Mr Mark Dixon
Project Manager
Dixon Sand (No. 1) Pty Ltd
4610 Old Northern Road
Maroota NSW 2756

13/05/2022

Haerses Road Quarry Modification 5 (DA 165-7-2005-Mod-5)
Request for additional information

FIGURE 1
Development Layout Plan

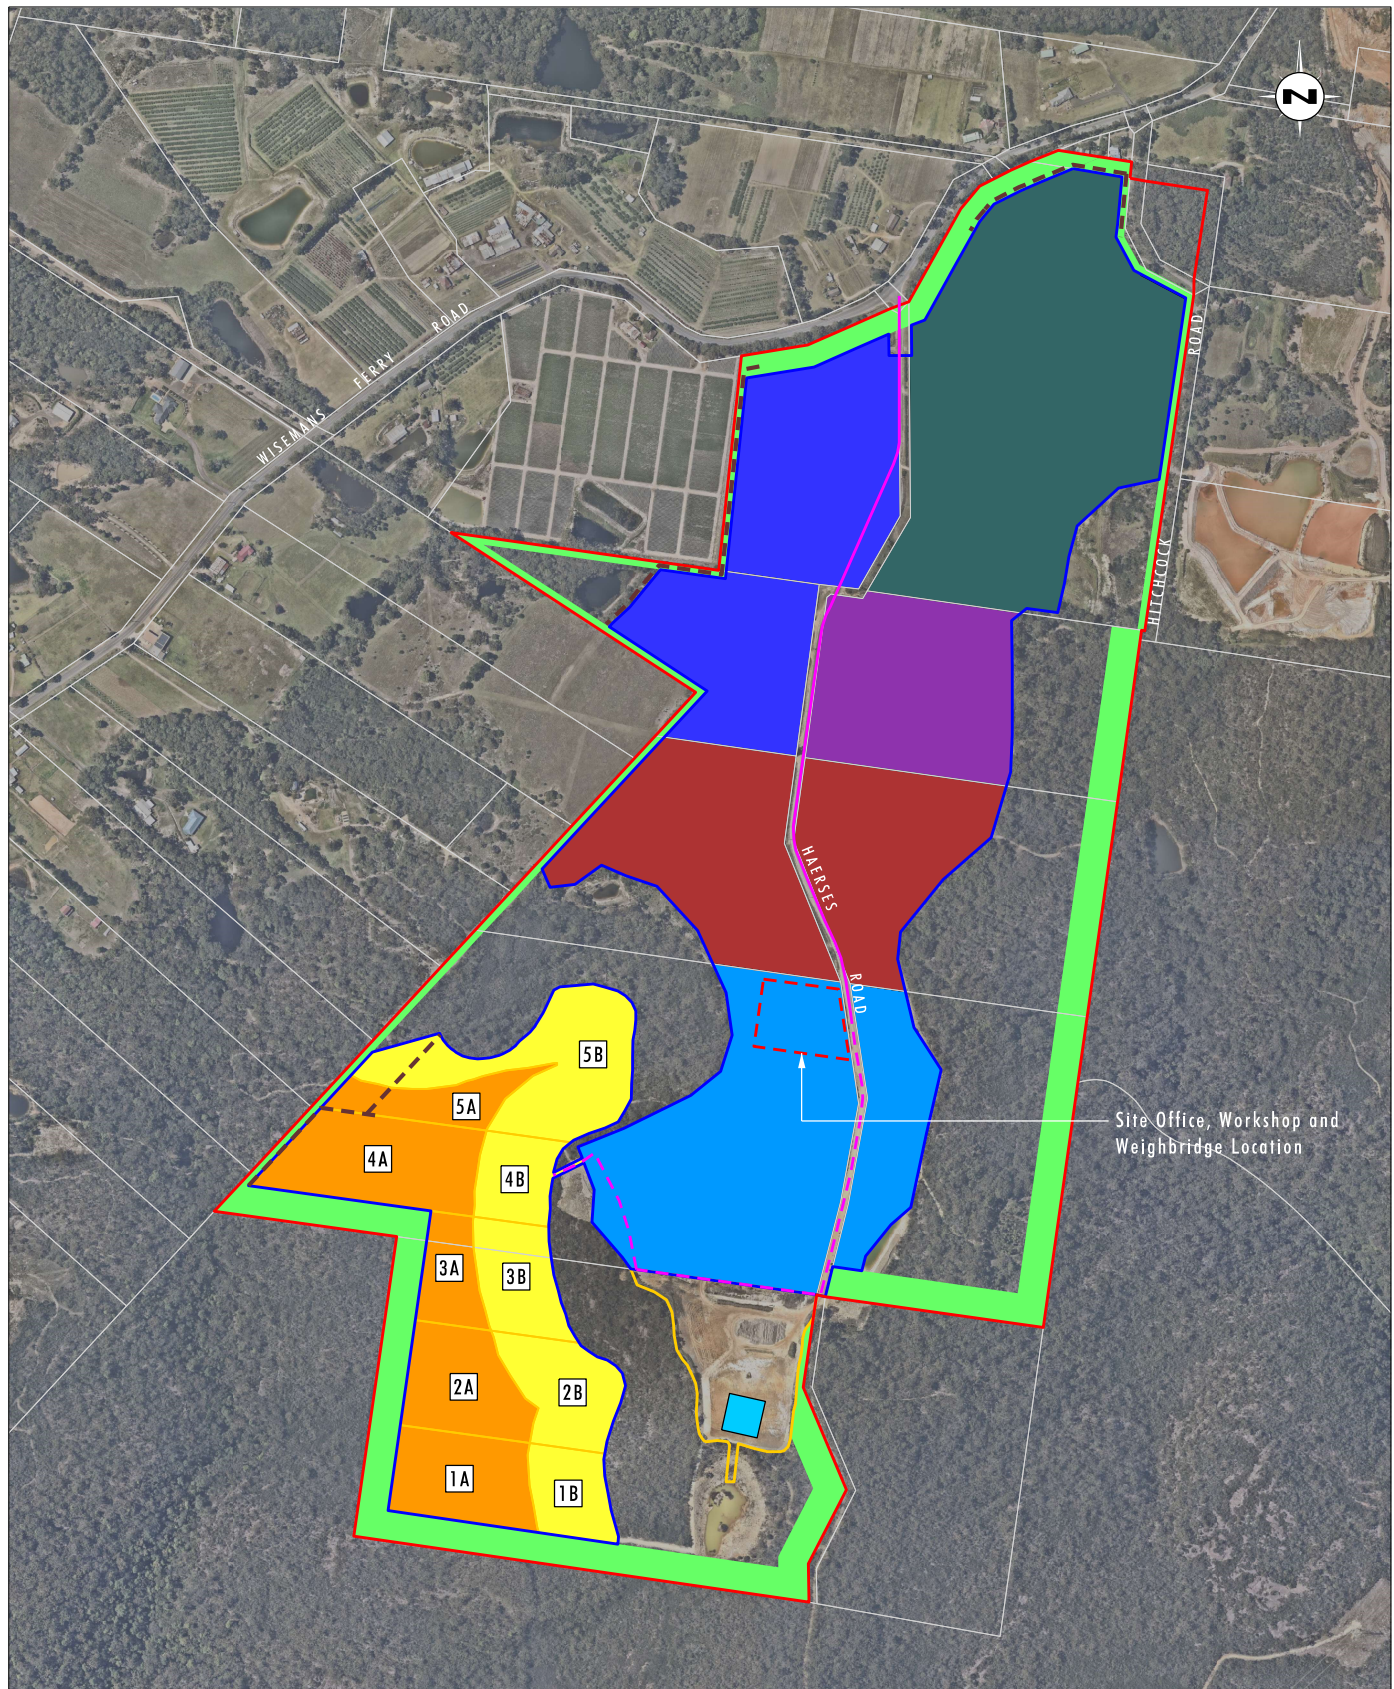
- a justification that the proposed change to the infrastructure boundary envelope within the site would not increase the previously assessed environmental impacts of the proposed modification;
- an updated set of figures for the updated project description; and
- replacement of the Porters Road Biodiversity Offset Area included in the consolidated consent with a figure that reflects the final boundary for the site in the Biobanking Agreement.
